**Submission in response to the Notification Dated 28 March 2017
State Significant Development Application for State 1 concept approval
For the construction and use of a 50 storey (RL198.22) mixed use building
D/2017/349 (SSD 8105) - 201 Elizabeth Street, Sydney**

I represent a number of owners of property within the neighbouring Park Regis building on 27 Park Street Sydney. I am writing to object to certain aspects of the proposal.

Private View Analysis | 27 Park Street

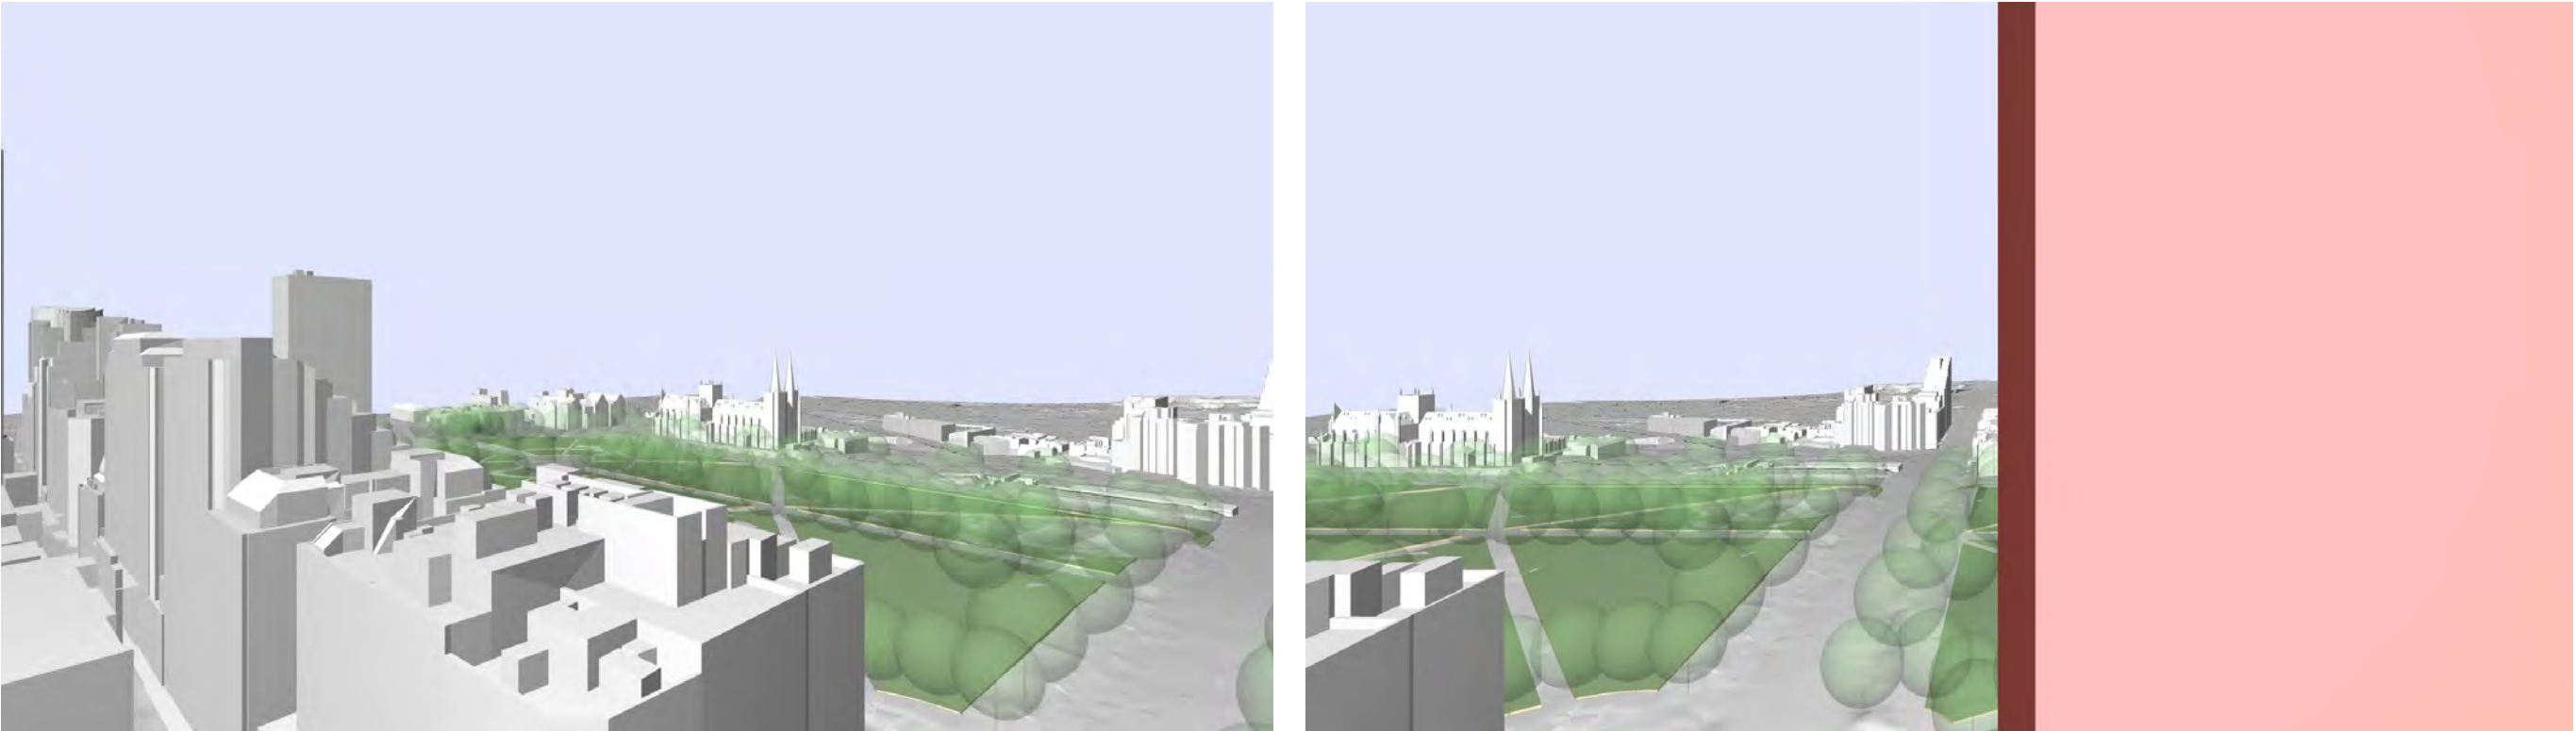
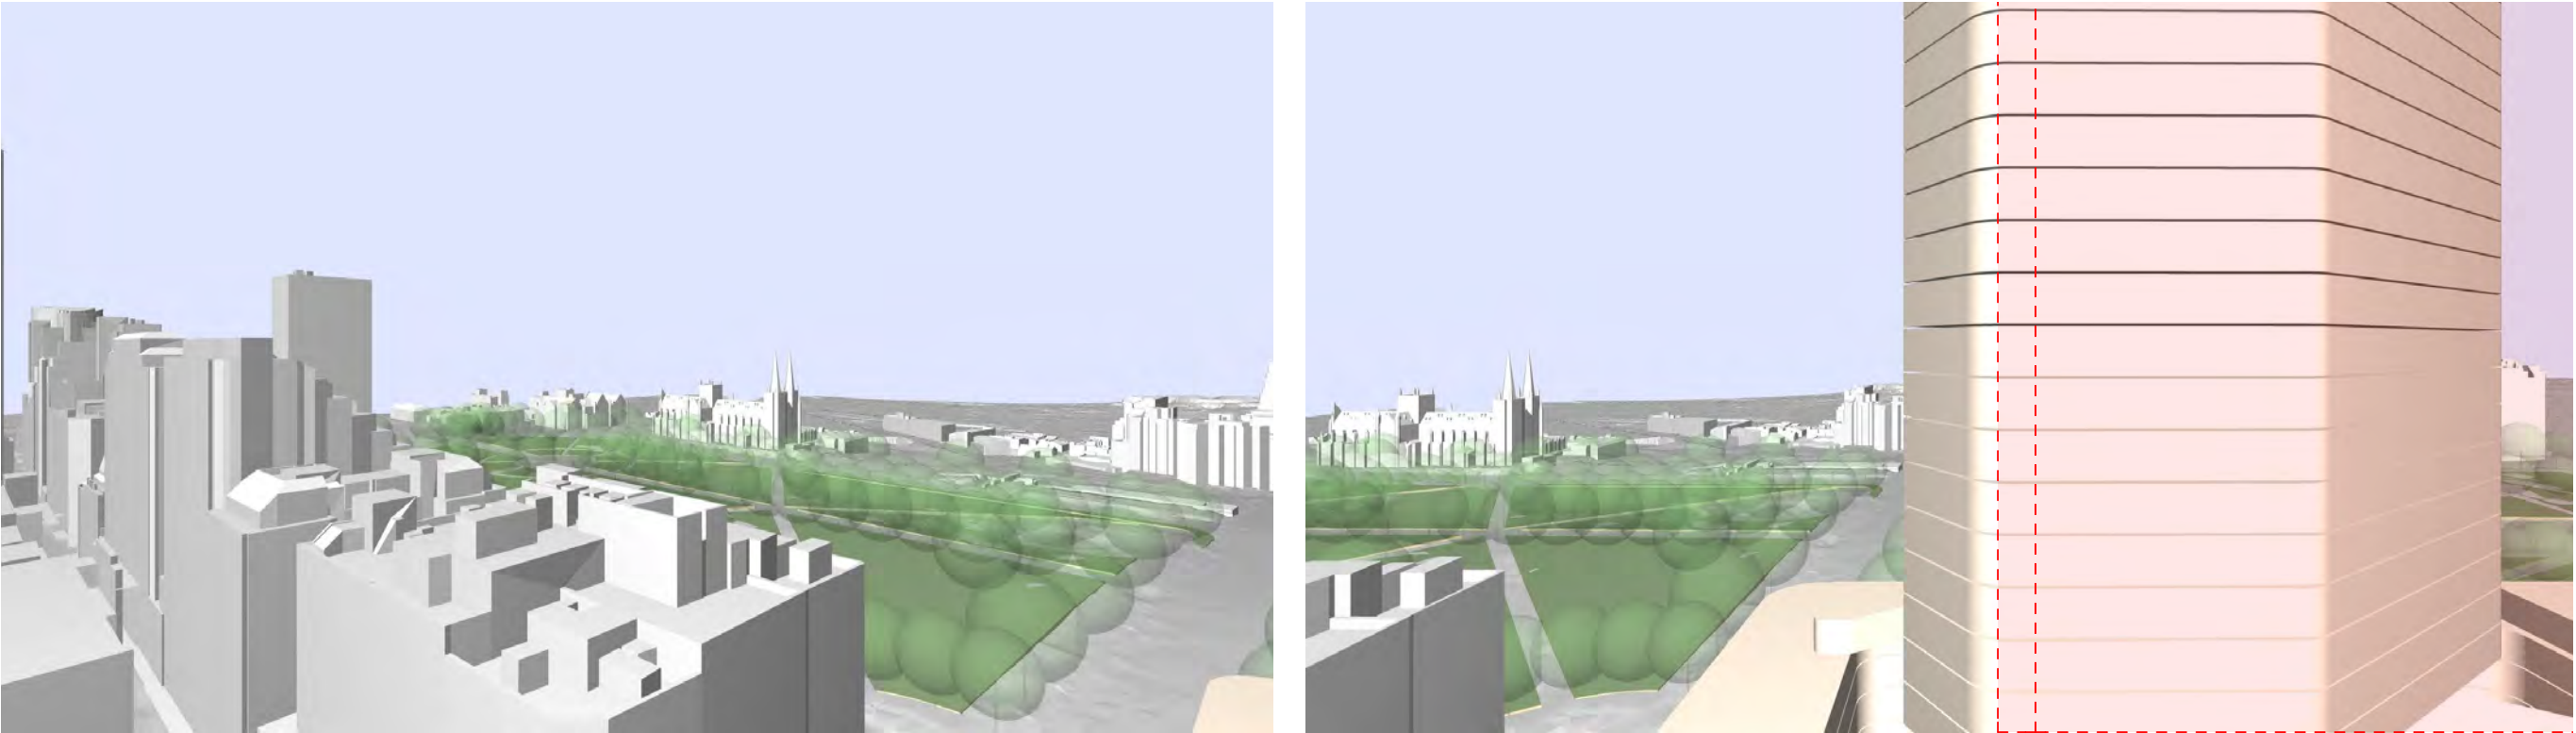
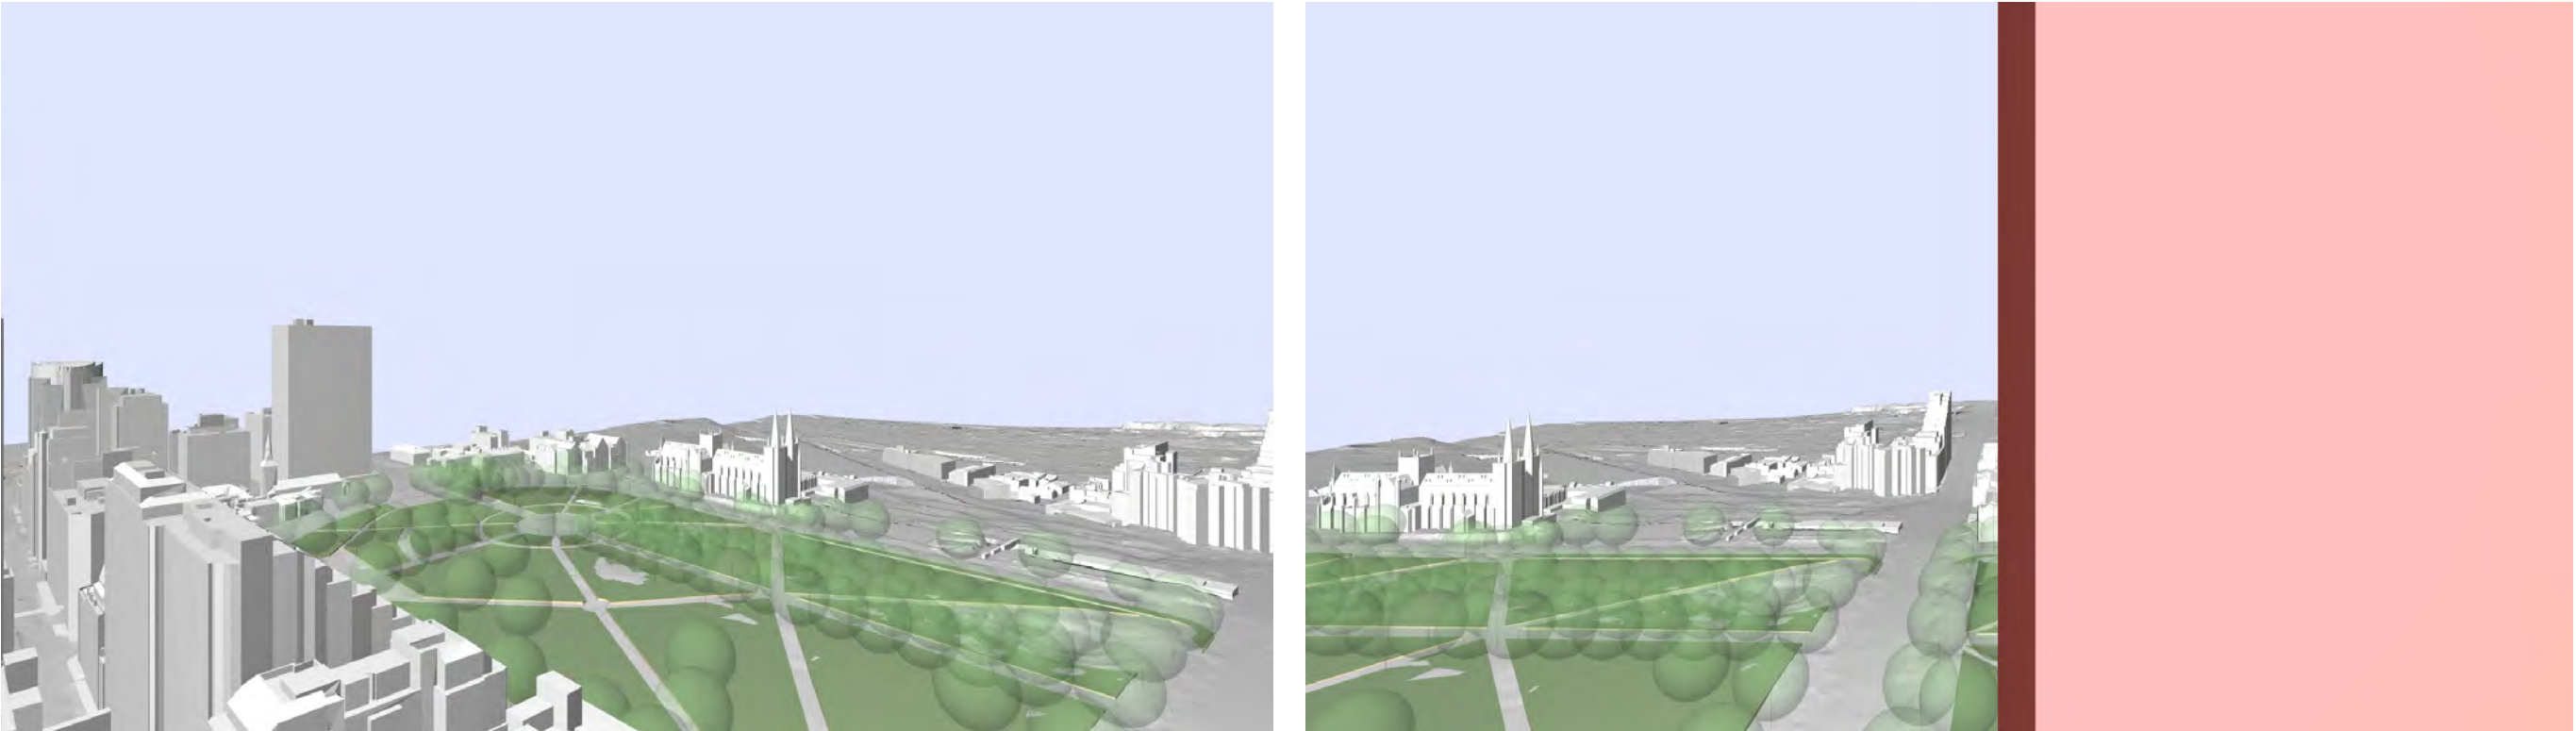
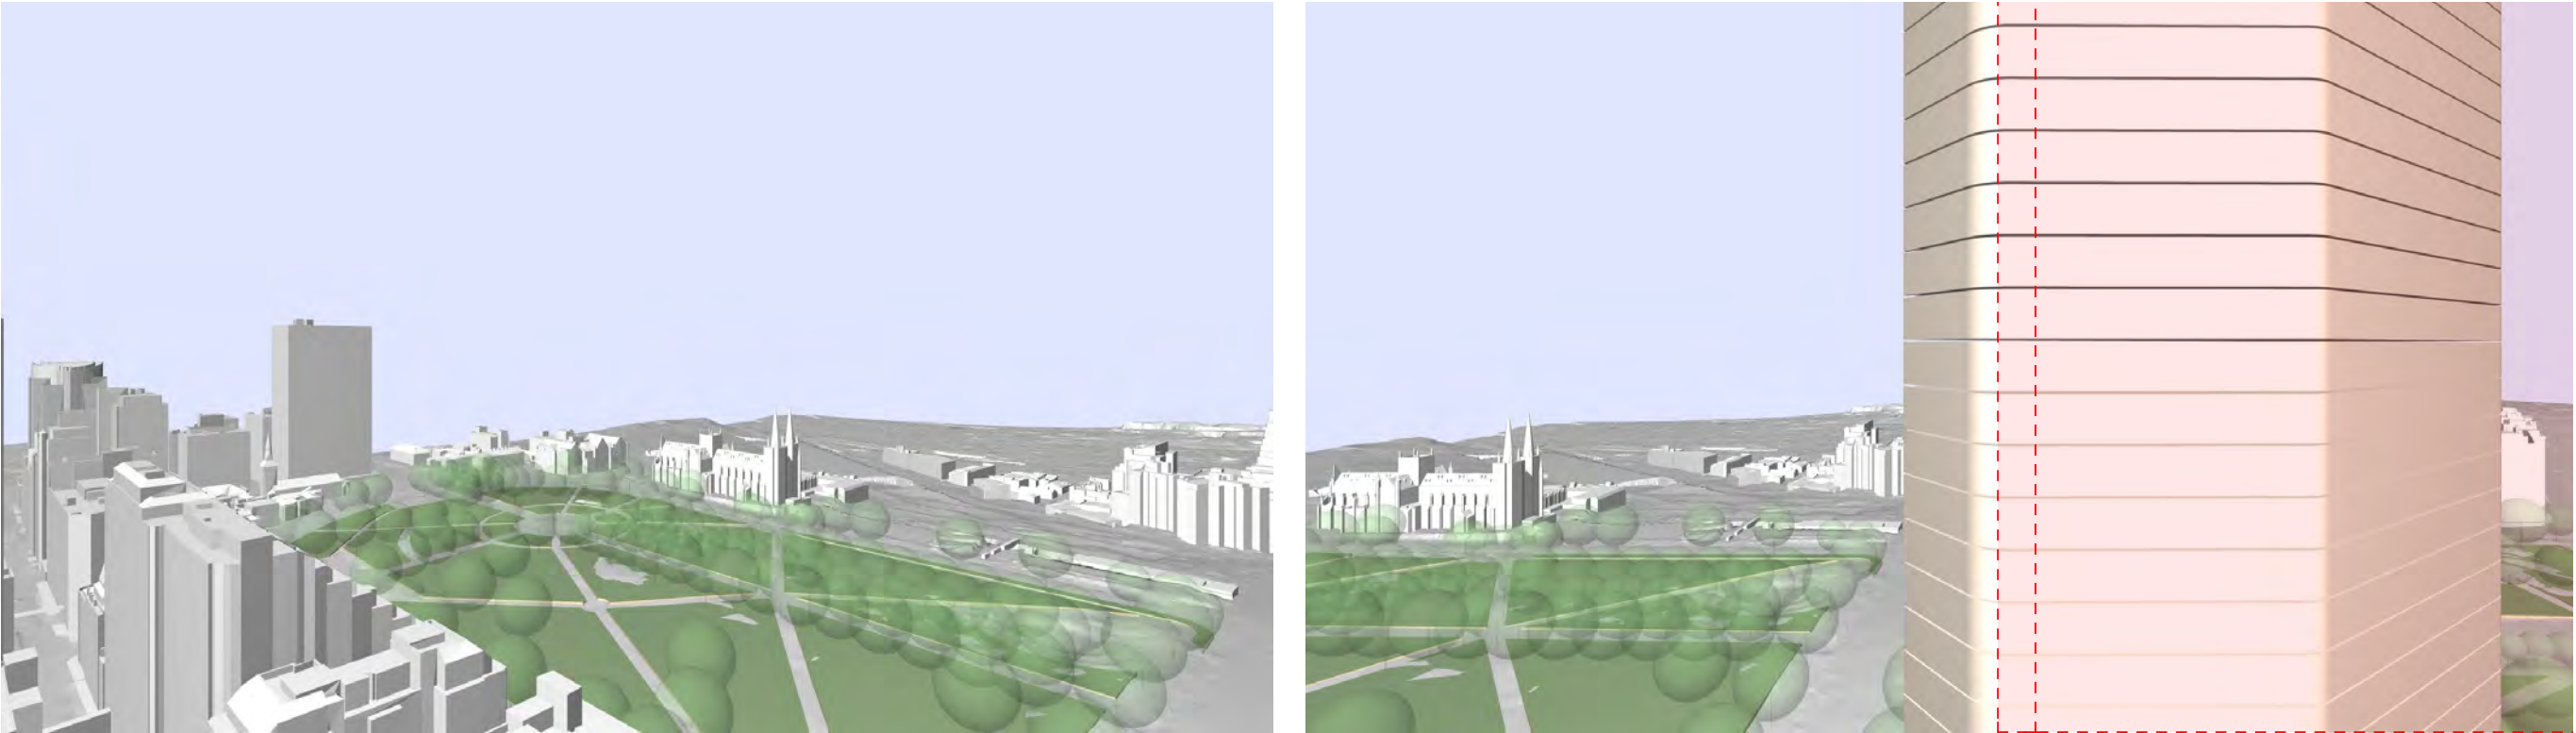
1 – The movement north of the new residential tower (north of the current tower) and closer to Park Street grossly affects the amenity of residents in the Park Regis building particularly the upper levels. A substantial portion of the East and North East view corridors are significantly “stolen” by this shift to the detriment of the Park Regis, which is totally unnecessary, given that the existing 201 Tower already enjoys the most prominent and totally uninterrupted views over Hyde Park and to the East and North East directions. Again, this proposed shift in the massing is unnecessary in the levels above the hotel component and to the detriment of the Park Regis residents.

1A - As a possible solution, to ensure preservation and equitable sharing of the existing view corridors by 201 Elizabeth St and Park Regis, the height of the new residential tower could be built even higher than current, on the proviso that it does not shift bulk or massing of the residential tower component to the north towards Park Street as currently proposed. This section of the tower should remain setback to the northern line of the current tower building footprint.
